9 April 2020

TfNSW Reference: SYD19/01554/02  
Council Reference: SSD 10404

**REVIEW OF EIS FOR HORSLEY DRIVE BUSINESS PARK STAGE 2  
CNR COWPASTURE ROAD AND TRIVETT STREET, WETHERILL PARK**

Figure 13: Cowpasture Road / Trivet Street / HDBP Stage 2 Access

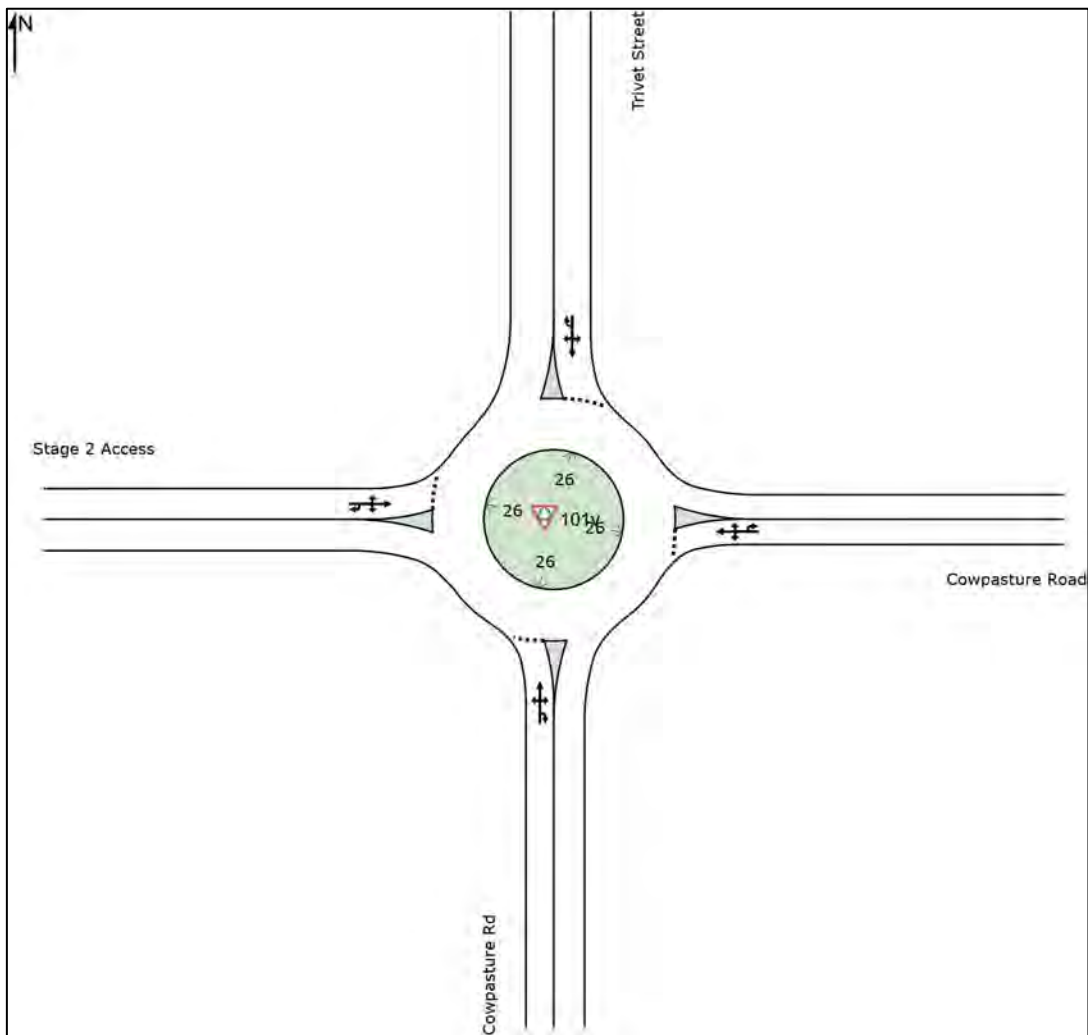
1. It is noted the majority of impact of the proposed development will be at the intersection of Cowpasture Road and Trivett Street, Wetherill Park. This intersection is the responsibility of Fairfield Council. It is also noted that proposed intersection works are reflected in SSD 7664 (MOD 1).
2. It is noted Cowpasture intersects with The Horsley Drive, a classified road. The intersection will receive greater traffic volumes from the M7 with the future widening of the Horsley Drive. Priority would be given to southbound and northbound right turns to minimise overflow to the roundabout of The Horsley Drive/Cowpasture Road/Lizard Log access, therefore motorists turning right from Cowpasture Road/Victoria Street must accept delays for the intersection growth. Extra capacity or alternate access onto The Horsley Drive should be considered.
